STERLING RANCH RD & BRIARGATE PKWY.  
SEGMENT 2 GESC  
GRADING AND EROSION CONTROL PLAN  
ADDENDUM

DESIGNED BY	MAW	SCALE	DATE	4/29/24
DRAWN BY	MAW	(H) 1" = 100'	SHEET	4A OF 9
CHECKED BY	(V) 1" = N/A	JOB NO.	1183.30

STERLING RANCH RD & BRIARGATE PKWY.  
SEGMENT 2 GESC  
GRADING AND EROSION CONTROL PLAN  
ADDENDUM  
DESIGNED BY MAW SCALE DATE 4/29/24  
DRAWN BY MAW (H) 1"= 100' SHEET 4B OF 9  
CHECKED BY (V) 1"= N/A JOB NO. 1183.30

STERLING RANCH RD & BRIARGATE PKWY. SEGMENT 2 GESC GRADING AND EROSION CONTROL PLAN ADDENDUM			
DESIGNED BY	MAW	SCALE	DATE 4/29/24
DRAWN BY	MAW	(H) 1" = 100'	SHEET 4B OF 9
CHECKED BY	(V) 1" = N/A	JOB NO.	1183.30

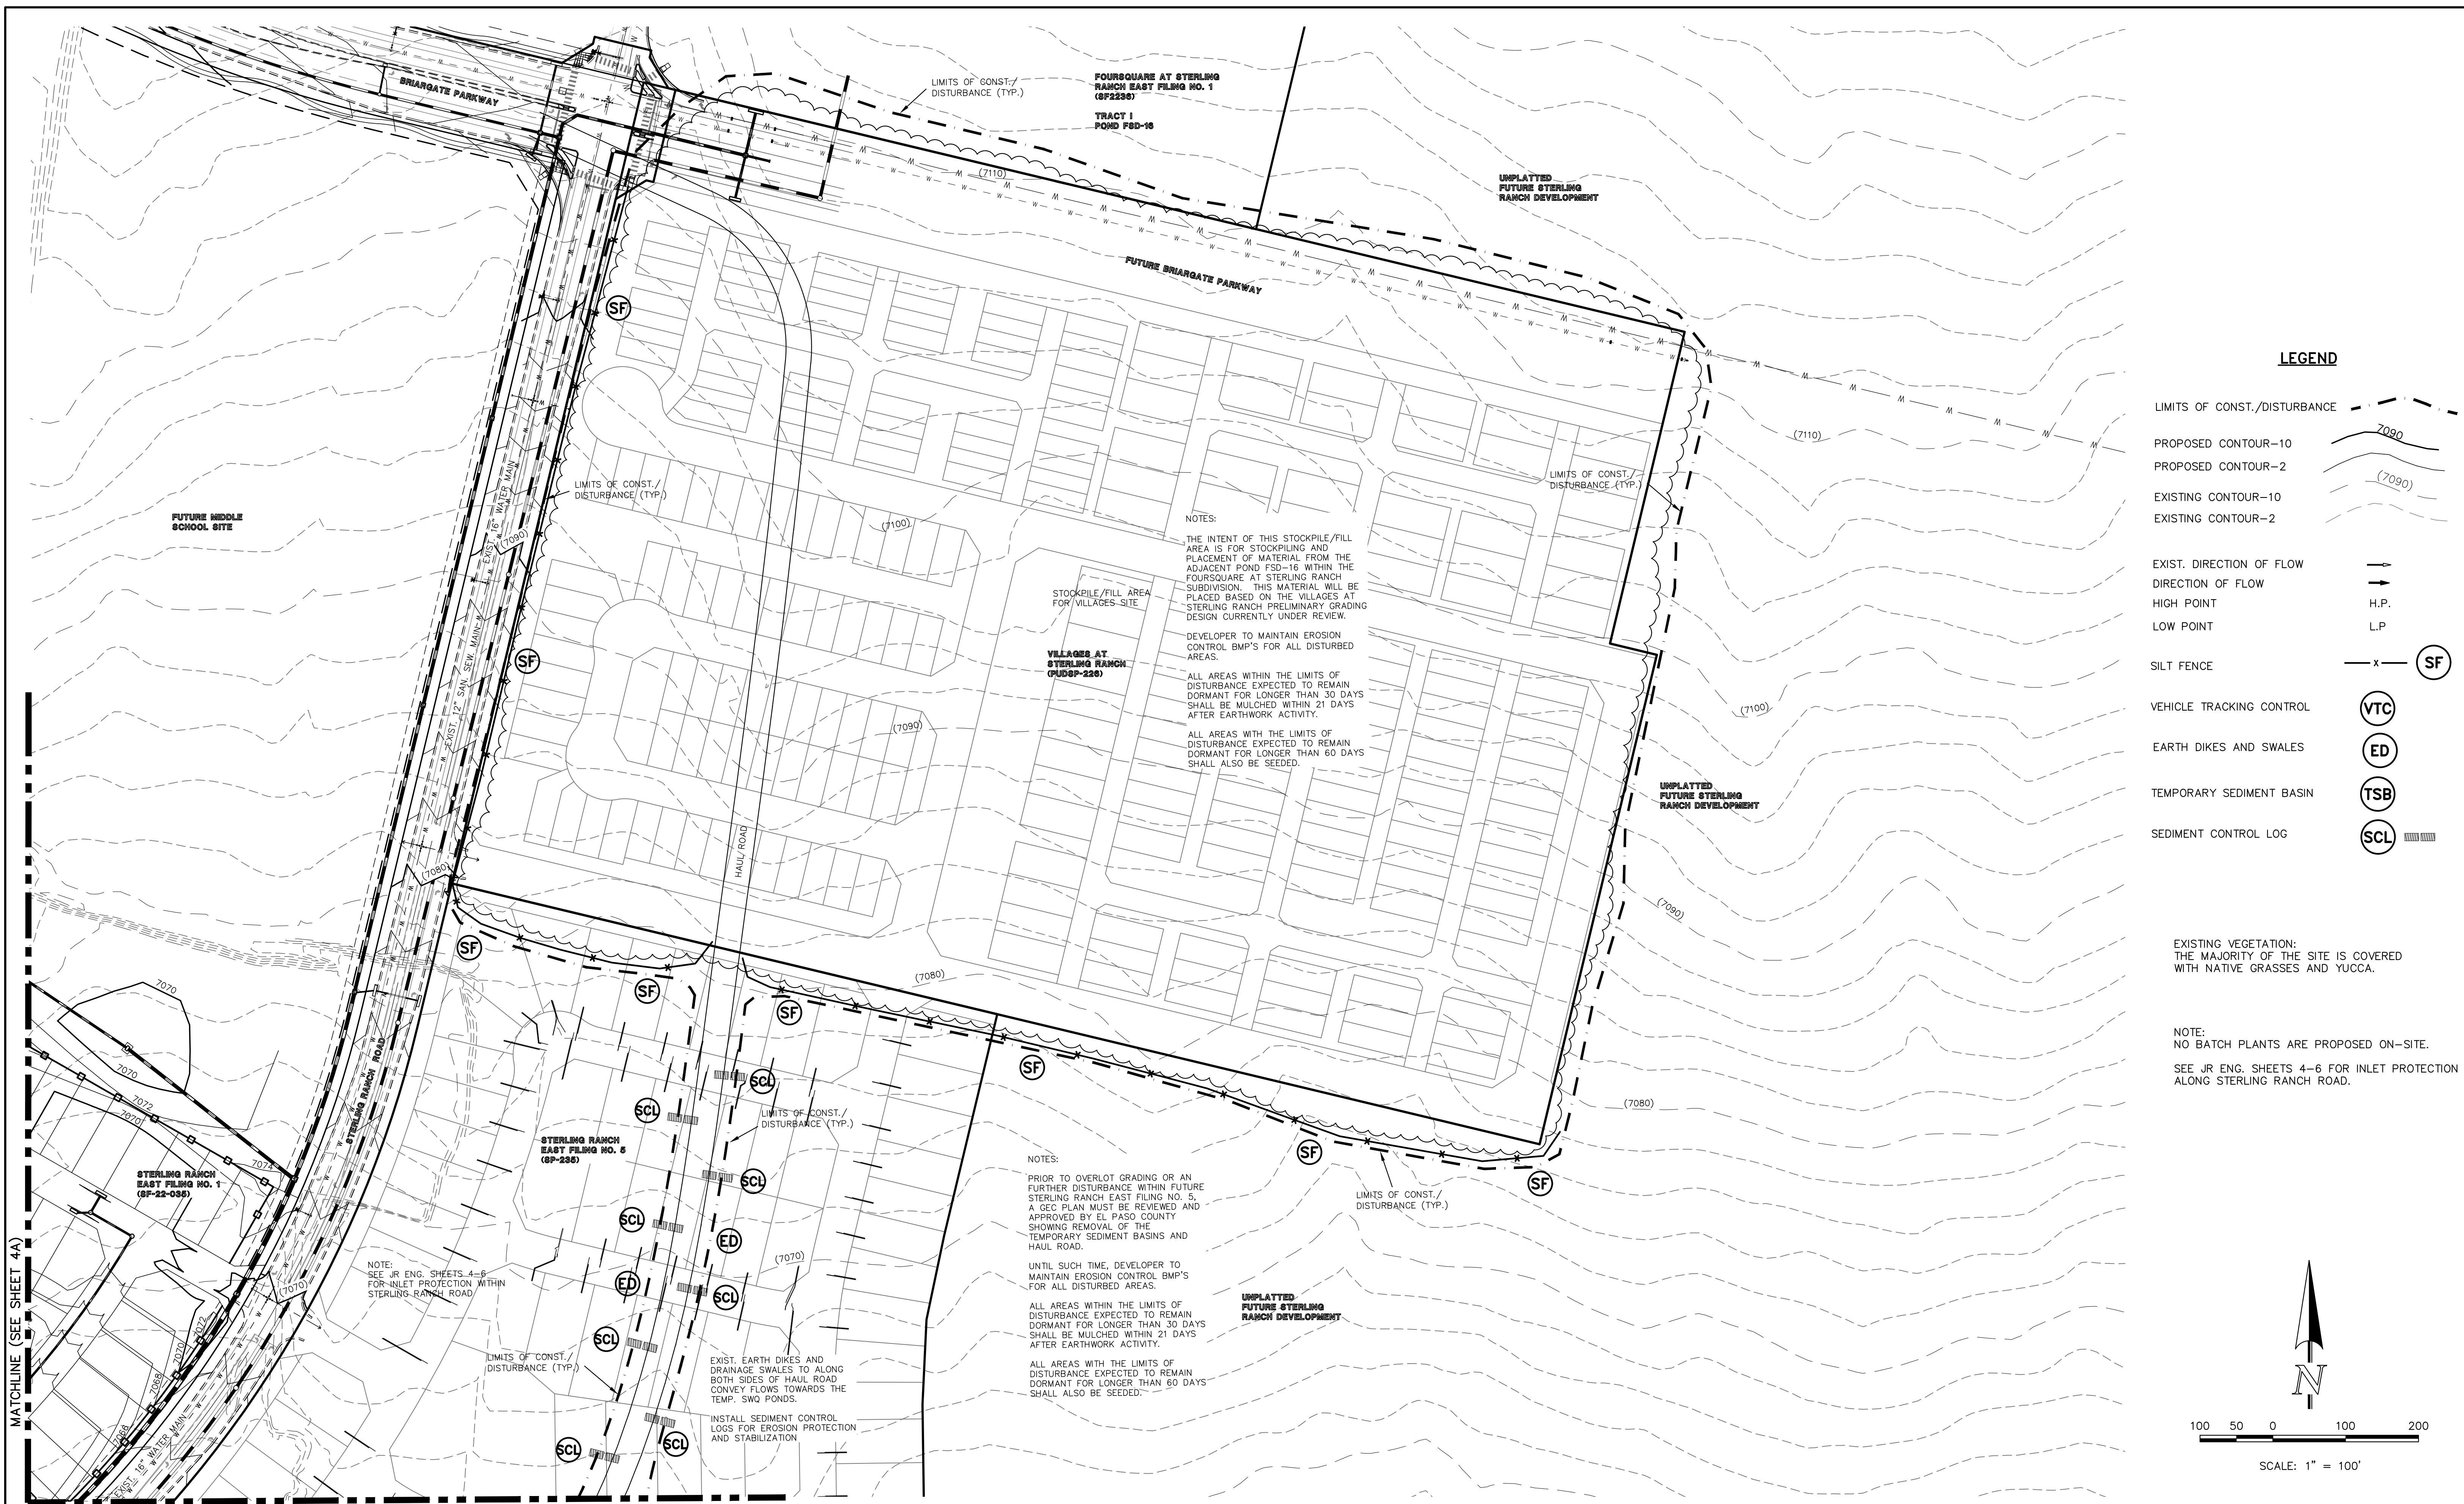
show entire LOD to be included with this scope/ESQCP. As shown, the limits are cutoff.  
Or if the rest of the unpermitted disturbances north and west of here will be added to the Briargate Bridge ESQCP or some other ESQCP, please state that here.

Consider need for a swale or berm along the road to convey flows to TSB.

See comment on previous page regarding TSBs.  
Also, runoff tributary to these TSBs previously sheet-flowed across the surrounding land. Now the TSBs will discharge these flows as a concentrated flows. Please address this by providing a suitable outfall (riprap apron, flow path via swale) and/or some form of level spreader.

DESIGNED BY	MAW	SCALE	DATE	4/29/24
DRAWN BY	MAW	(H) 1" = 100'	SHEET	4A OF 9
CHECKED BY	(V) 1" = N/A	JOB NO.	1183.30

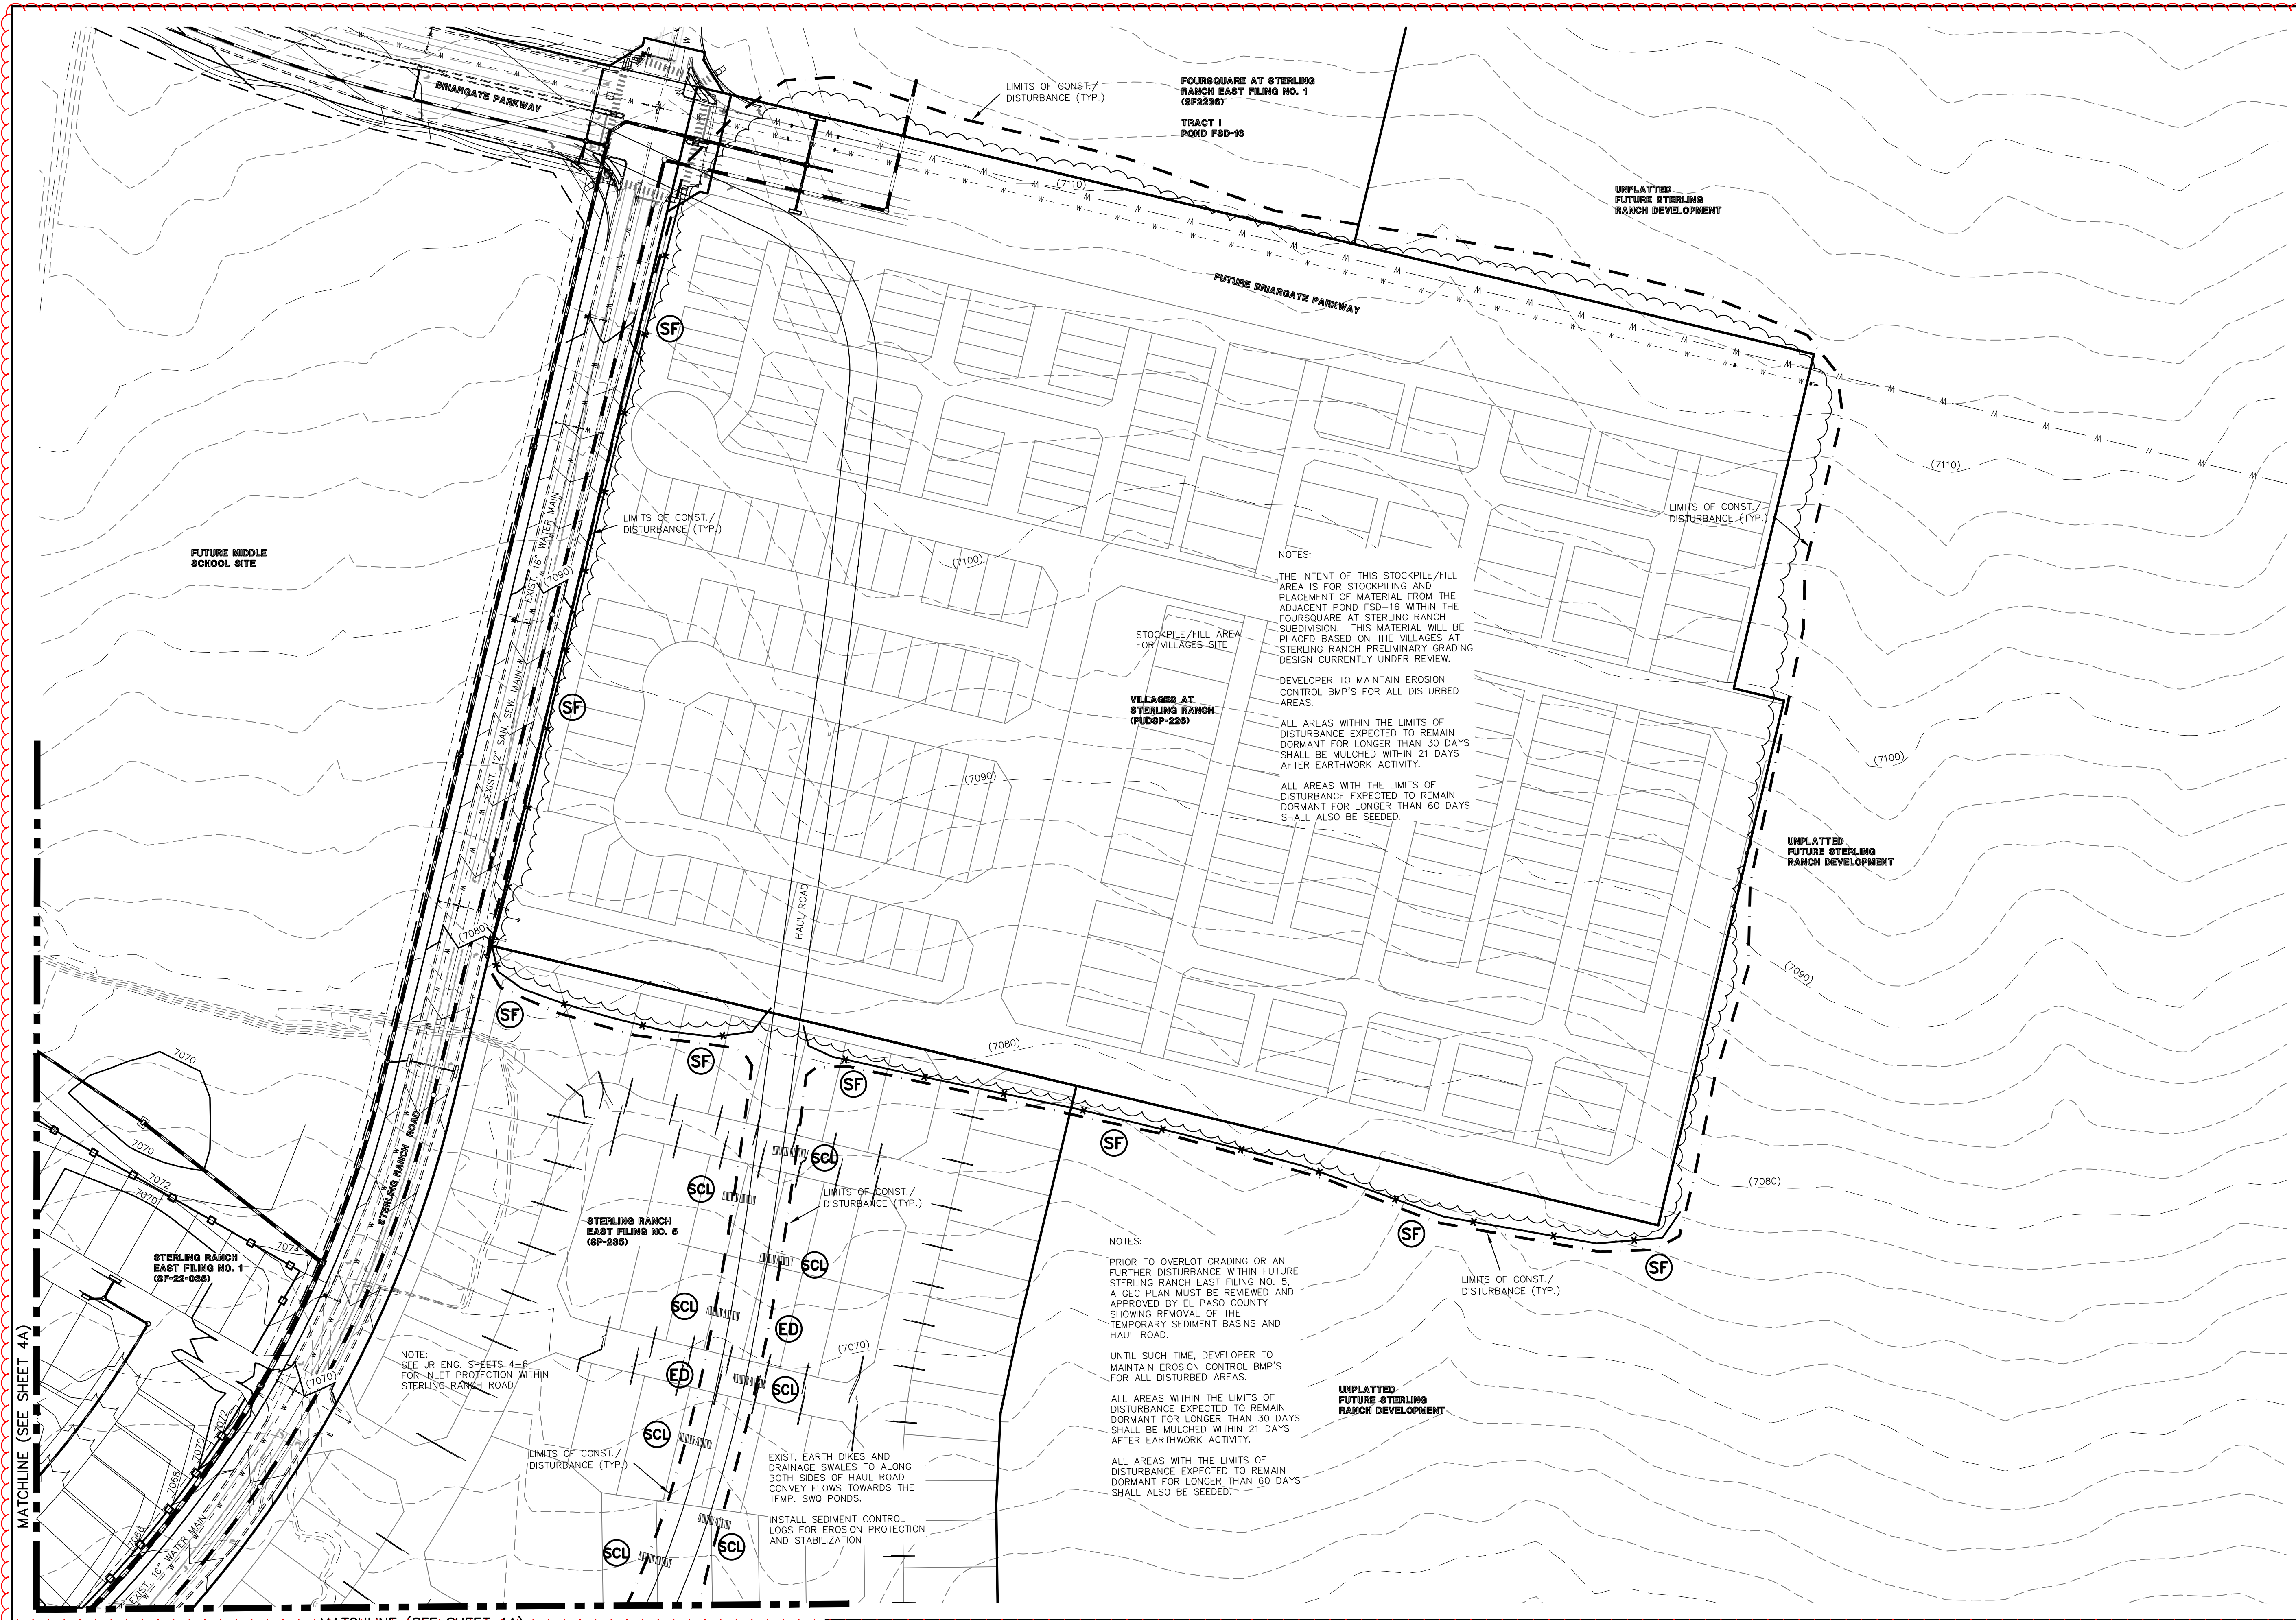
Provide details of temporary sediment basin including riser pipe diameter and perforation sizing, number of rows of holes, required volume, location of outlet pipe and spillway, and tributary area to the sediment basin. And provide contours for sediment basin.

Show proposed diversion ditches/swales to convey runoff to and from TSB.

Seeding: Revise plans according to DCMV2 - Section 3.2 - General Principles - Basic Grading, Erosion and Stormwater Quality Requirements and General Prohibitions #16:

"Soil erosion control measures for all slopes, channels, ditches, or any disturbed land area shall be completed within twenty-one (21) calendar days after final grading, or final earth disturbance, has been completed. Disturbed areas and stockpiles which are not at final grade but will remain dormant for longer than 30 days shall also be mulched within 21 days after interim grading. An area that is going to remain in an interim state for more than 60 days shall also be seeded. All temporary soil erosion control measures and BMPs shall be maintained until permanent soil erosion control measures are implemented."

For any of the areas within the LOD on either sheet that are not actively being graded, please show (or notate) areas to be seeded and this note about timing.

Add a general note: all areas to be vegetated with seeding should also be temporarily stabilized within 14 days of inactivity via surface roughening or some other means.

Show check dams, ECB, or some other forms of stabilization within dike/swale
